3rd June 2020

Re: Rye Park Wind Farm (SSD-6693 Mod 1) Tip Height Increase

Figure 1
Residential dwelling locations
within 4km of consented RPWF
wind turbines (north)

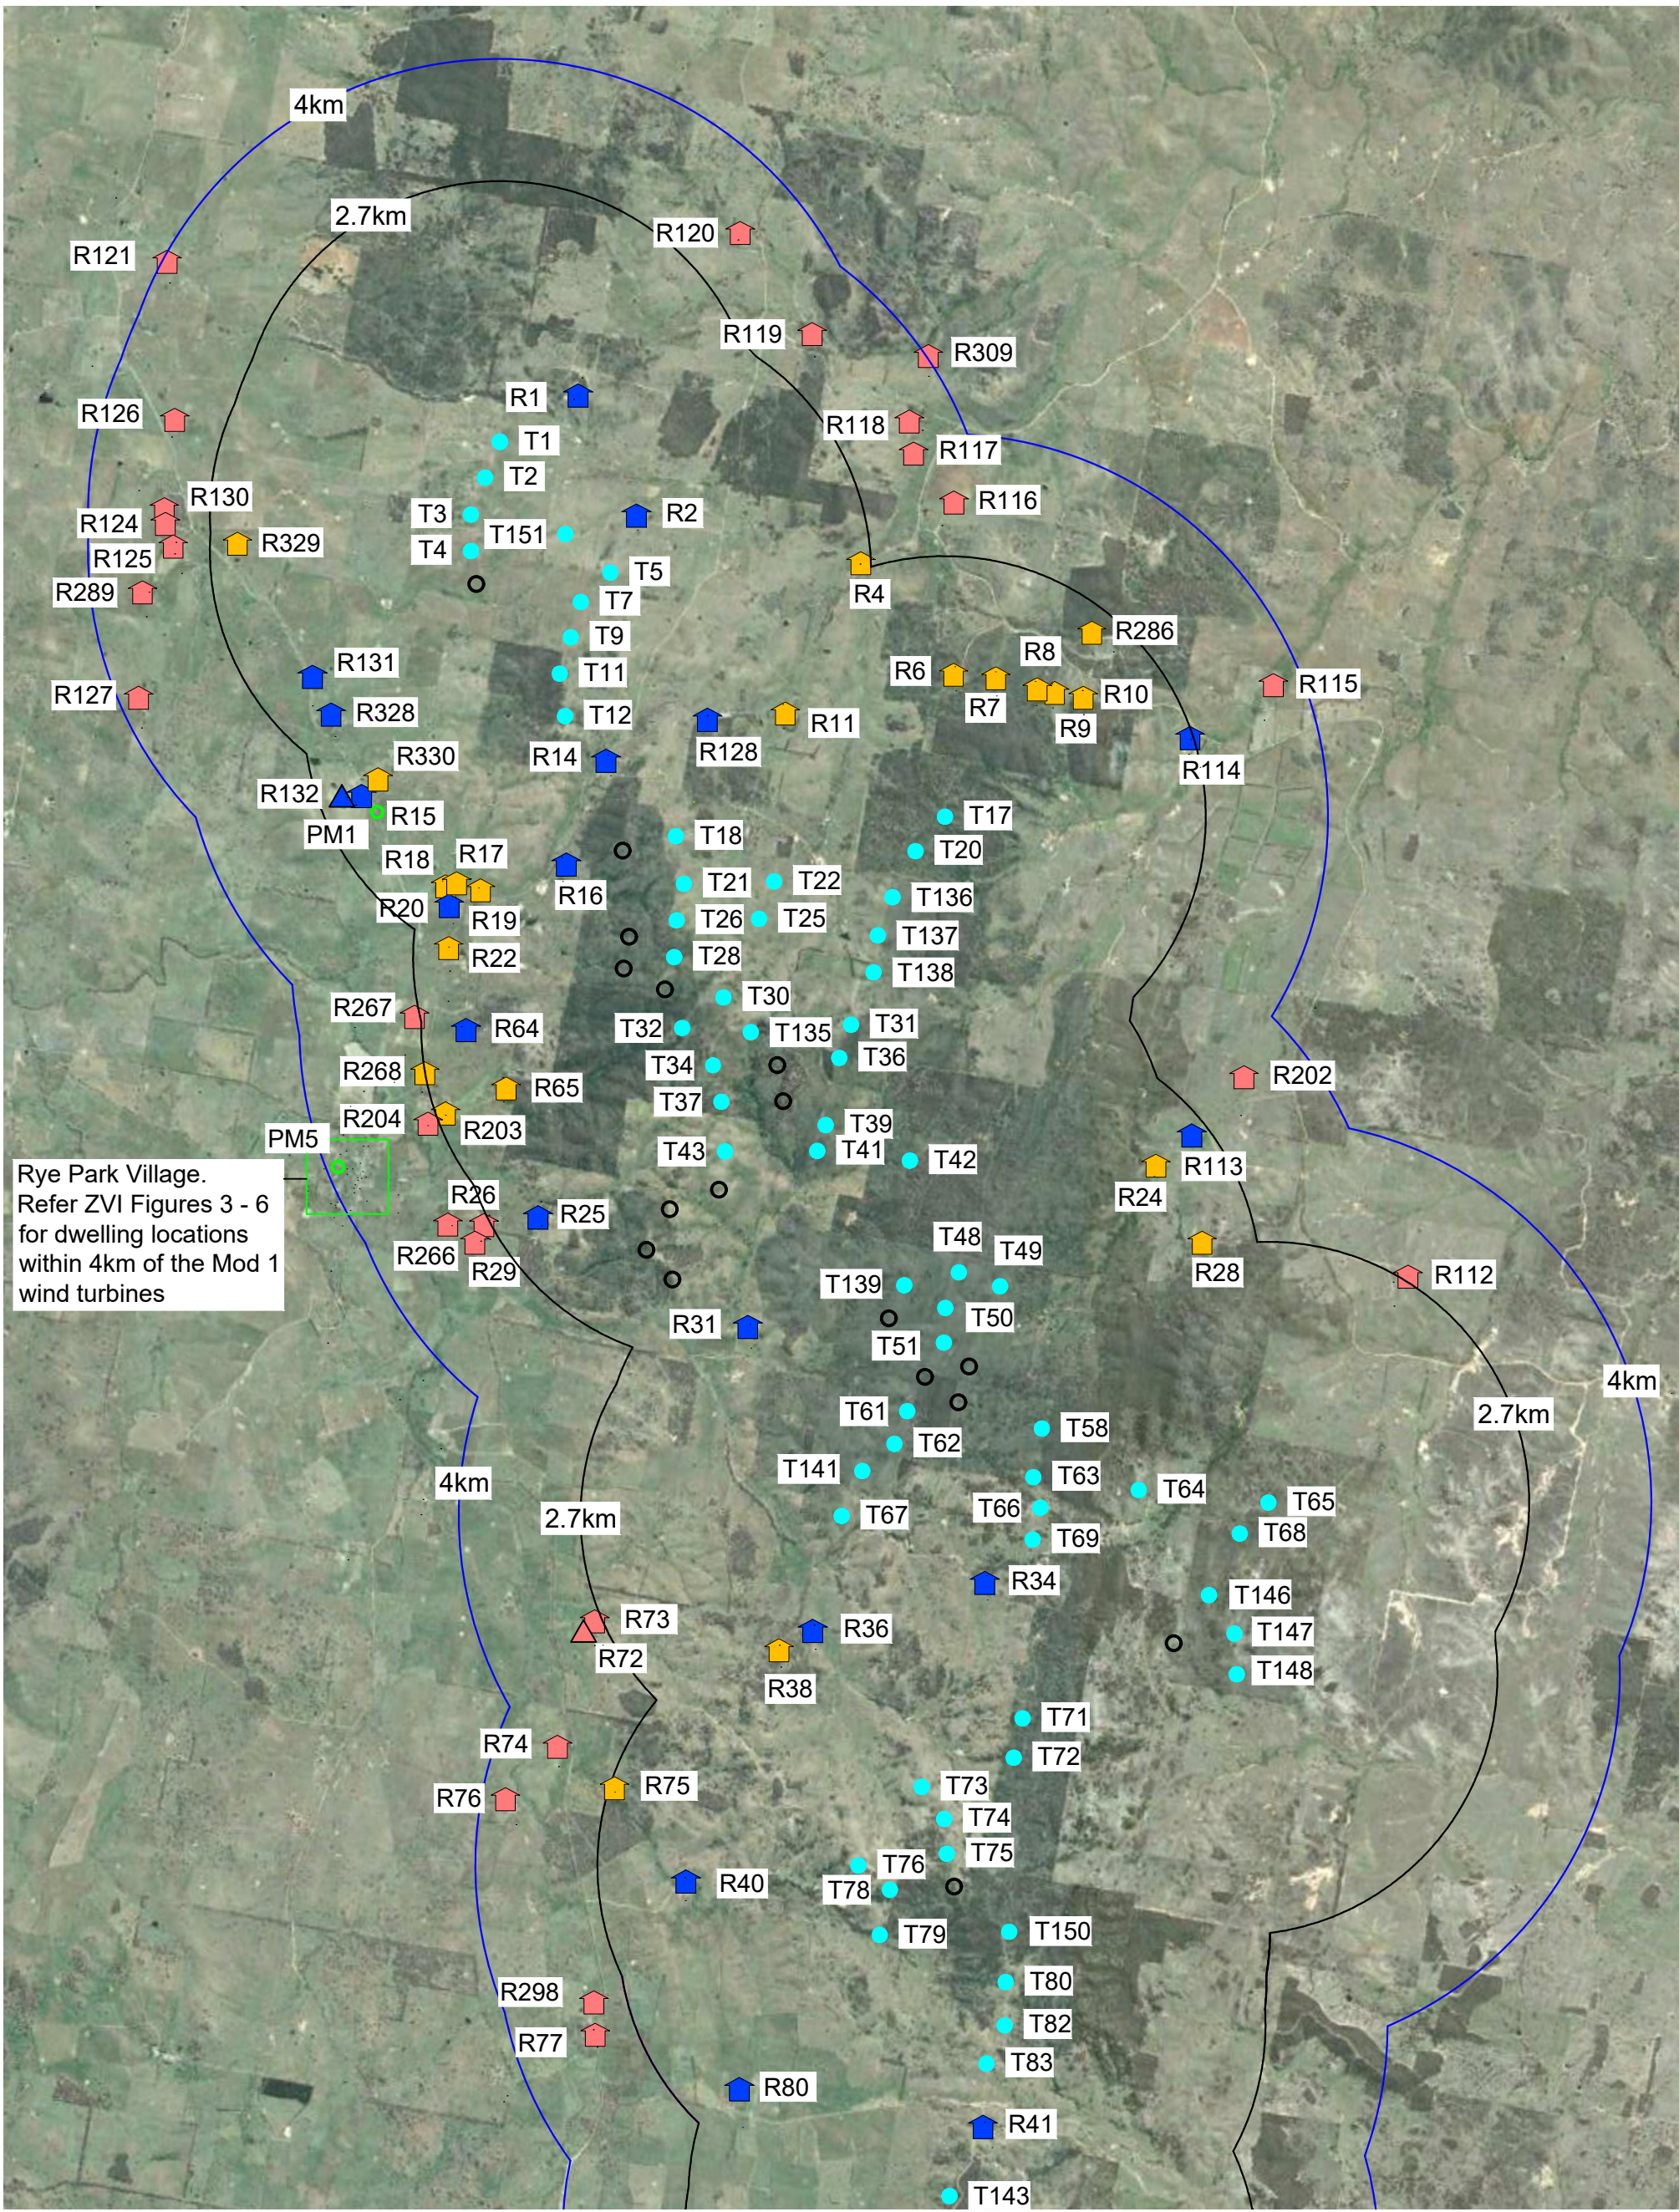
This leads to another concern I have and am finding hard to comprehend. The maps included in the documentation identify 330 residences but there would be many more that have not been identified, such as my son's home. The large number of homes and people are clearly seen on Figure 1 & 2 – Residential dwelling locations within 4km of consented RPWF wind turbines. As we know wind turbines can be seen and heard at much greater distances than 4km so I find it hard to comprehend how this development can even go ahead under the current consent, let alone with much larger turbines.

The closest turbines to me, T1 T2 T3 & T4, are located on the property of Linda and Paul Cavanaugh. These turbines, along with T151 and several others in the northern cluster, will be located in the corridor between 2 lots of vegetation. This placement can clearly be seen on Figure 1 – Residential dwelling locations within 4km of consented RPWF wind turbines (north). This couple have been office-bearers of the Boorowa Community Landcare group and I understand Mrs Cavanaugh is currently the liaison person between Local Land Services, landowners and funding opportunities. I find their position in the local Landcare group as being a conflict of interest when it is clear that when they are coordinating the distribution of hundreds of thousands of dollars to landholders for the building of tree lots to fill corridors to ensure the nesting ability and future of the Superb Parrot, and revegetation of the endangered Box Gum Grassy Woodland areas, they will be responsible for the building of several 200m high wind turbines in the corridor where the parrots, eagles and other birdlife will be travelling. It is also clear from looking at this map, along with Figure 2, the turbine placement will significantly impact the remnant vegetation in the area, and the animals that live there.
